**Our Case Number:** ACP-323606-25

**Re:** Proposed construction of 67 no. housing units  
on a site at Tyrells Land, situated along Stradbally Road, Portlaoise, Co Laois

Our Ref: C25-003 L2 - An Coimisiún Pleanála  
Reply to: 2 John St., Kilkenny, mail@boda.ie  
Date: 9<sup>th</sup> February 2026

**Re:** Tyrrell's Land, Stradbally Road, Portlaoise, Co. Laois Section 177AE  
**Re:** Case reference: ACP-323606-25  
**Client:** Christopher Fingleton and Mary Tyrrell, Portrane House, Stradbally Road, Portlaoise.

Drawing file: Architect / 2302-PA-005-Proposed Boundary Layout.pdf

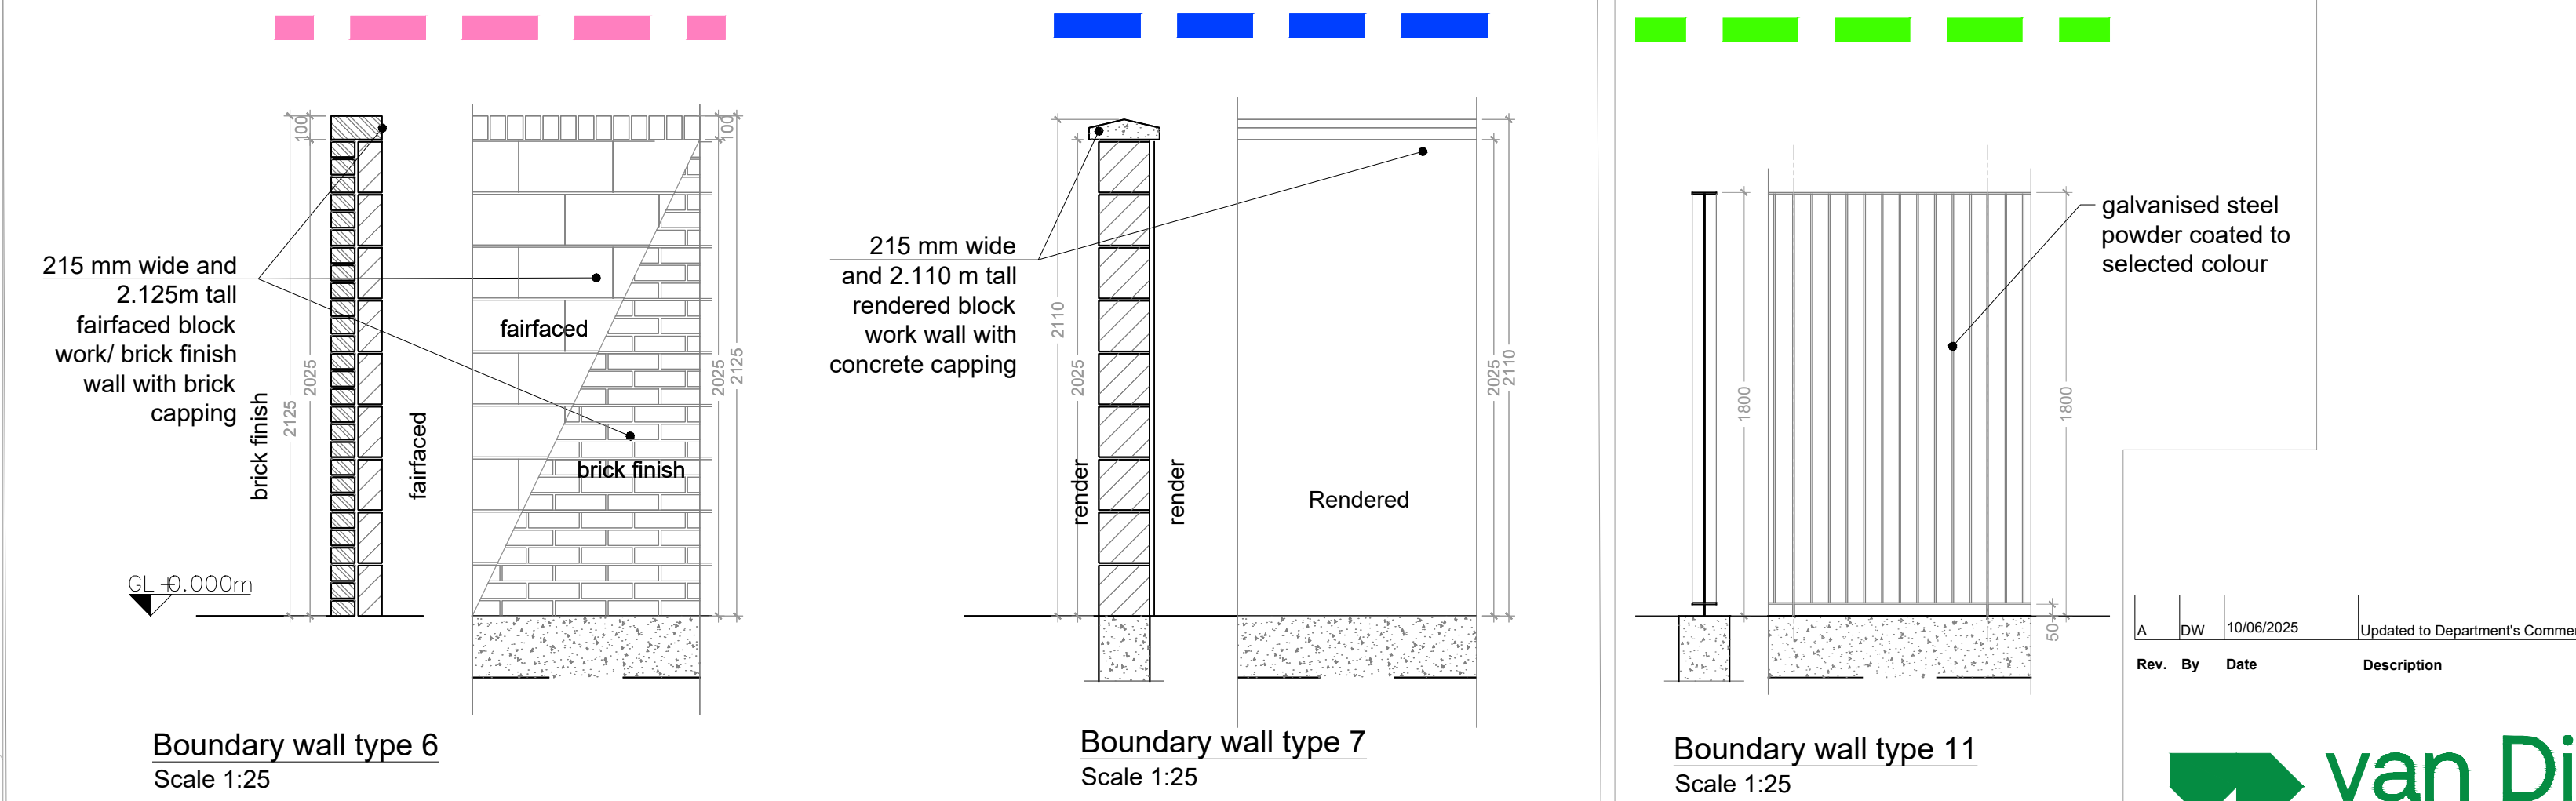
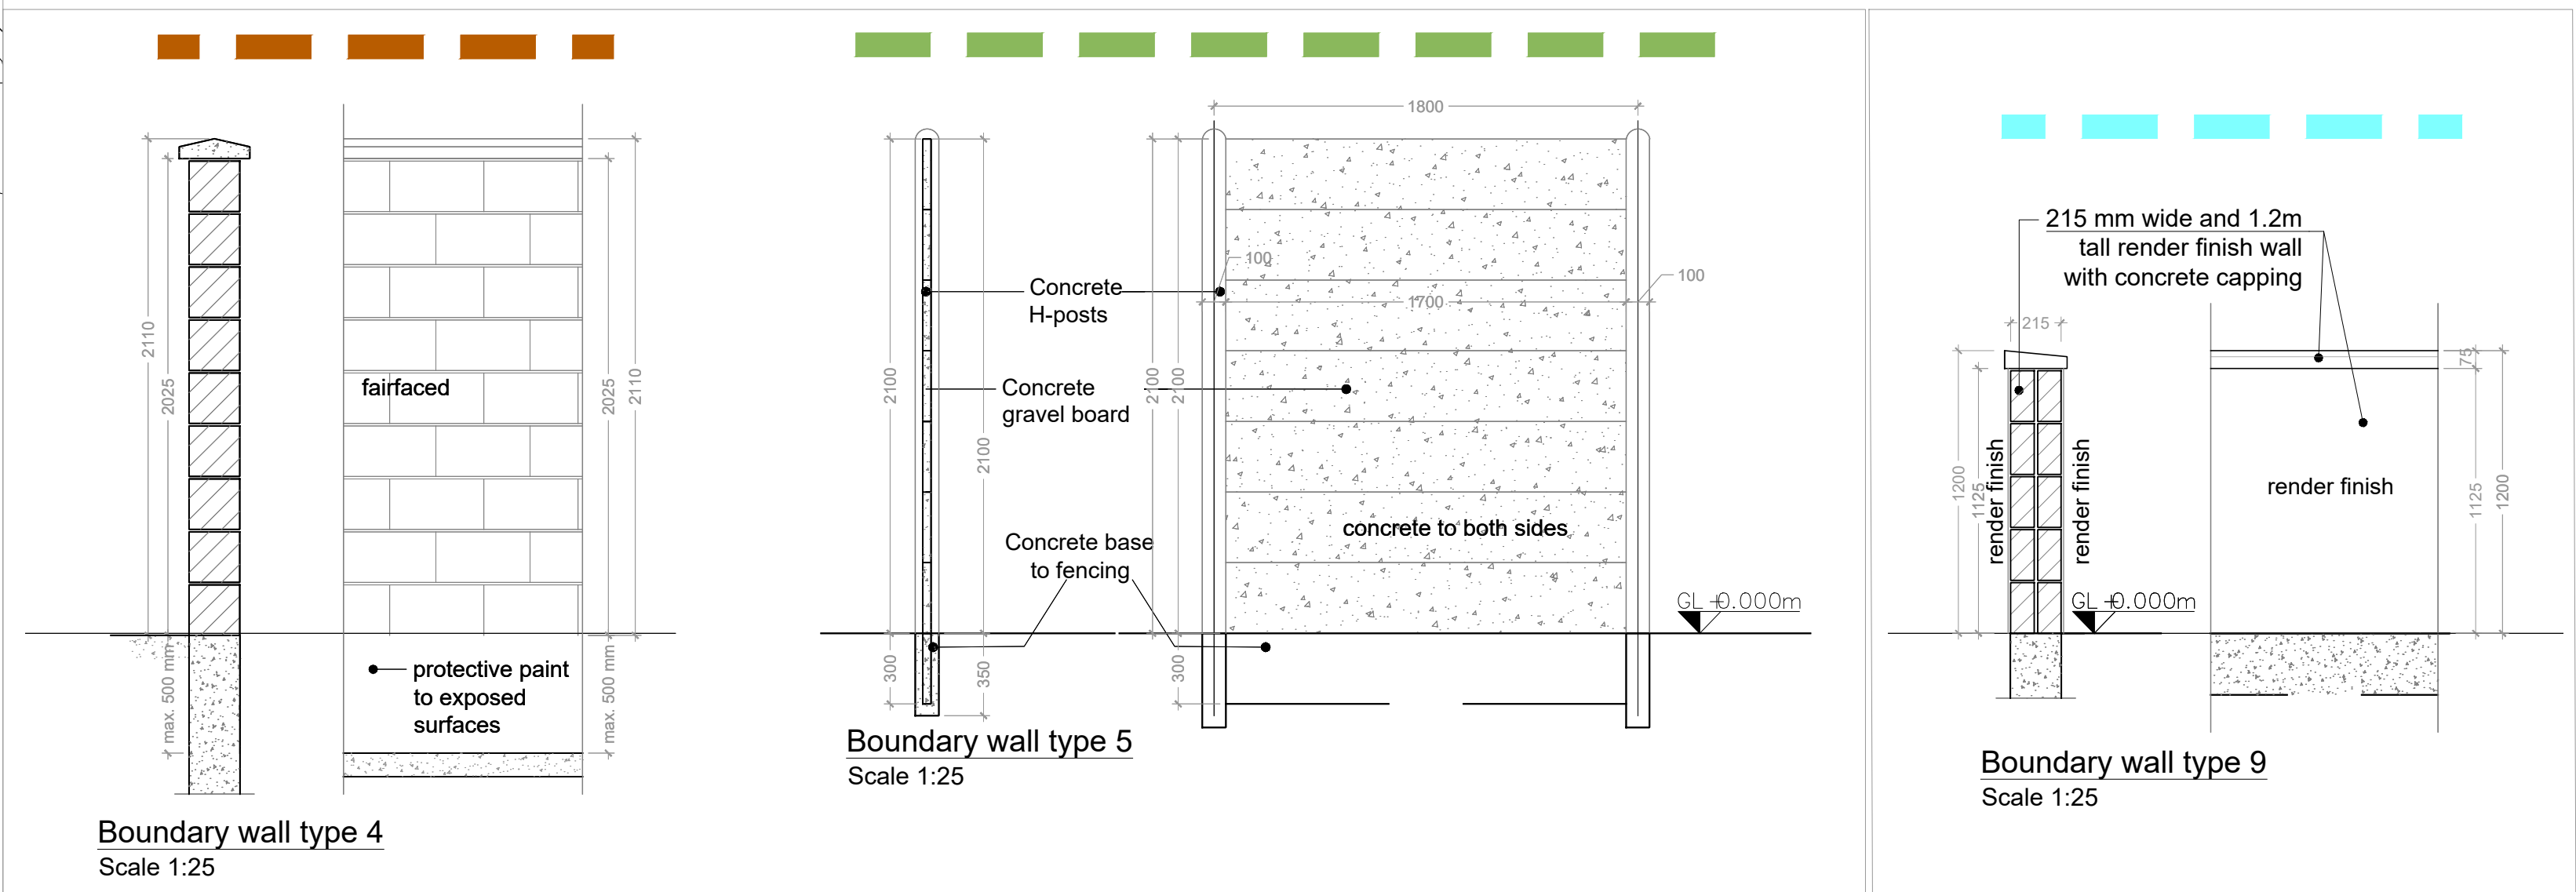
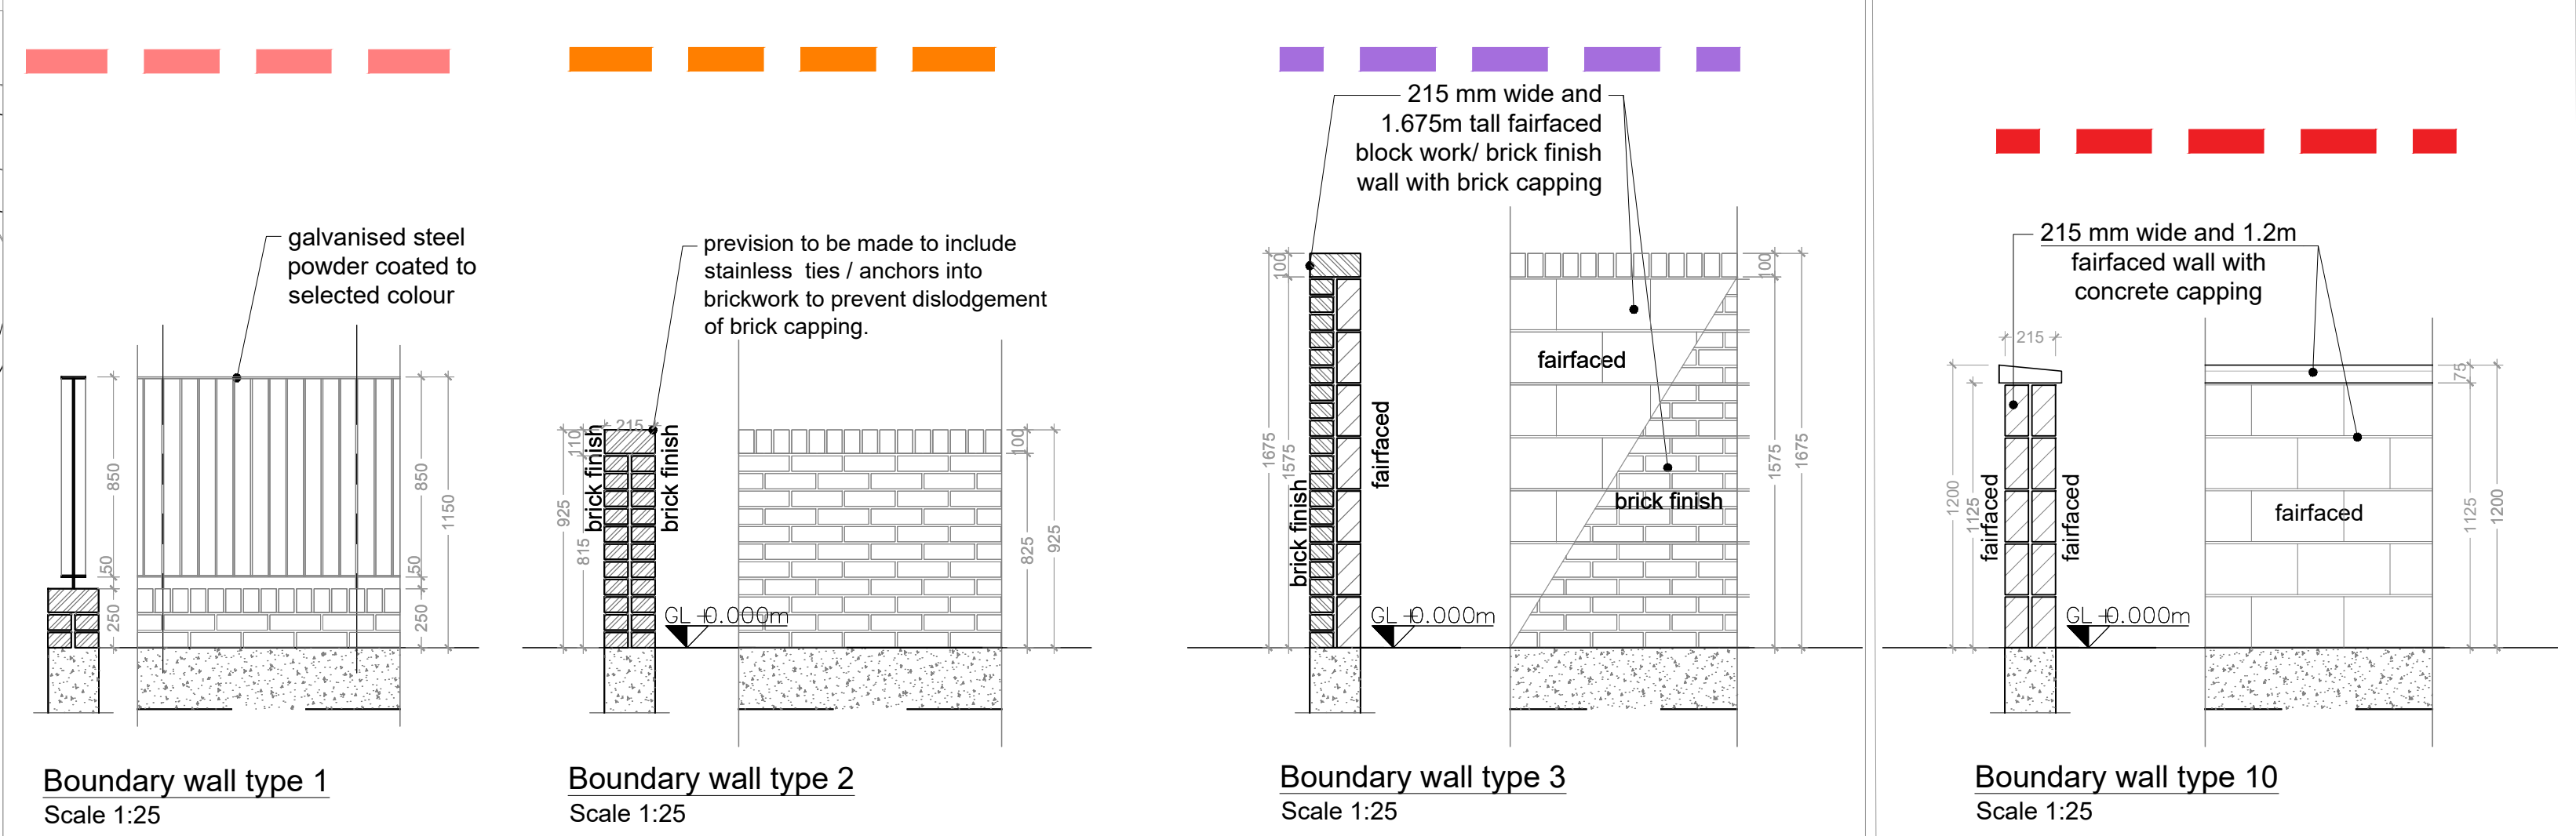
**Item 7** We also note the Council's comments regarding the boundary wall treatment.

***“ A 2m block wall with appropriate capped finish, landscape buffer, and native tree planting (already proposed) achieves: No adverse impact on heritage significance.”***

Please see Photo 1 from the Design Statement prepared by van Dijk Architects of the wall on the front boundary. This ties into the overall concept of the scheme. There is a requirement to respect the setting of the protected structure and where the vista is provided with an open space, the most appropriate wall finish would be stone masonry. This would be similar to the current setting walls as noted in the design statement.
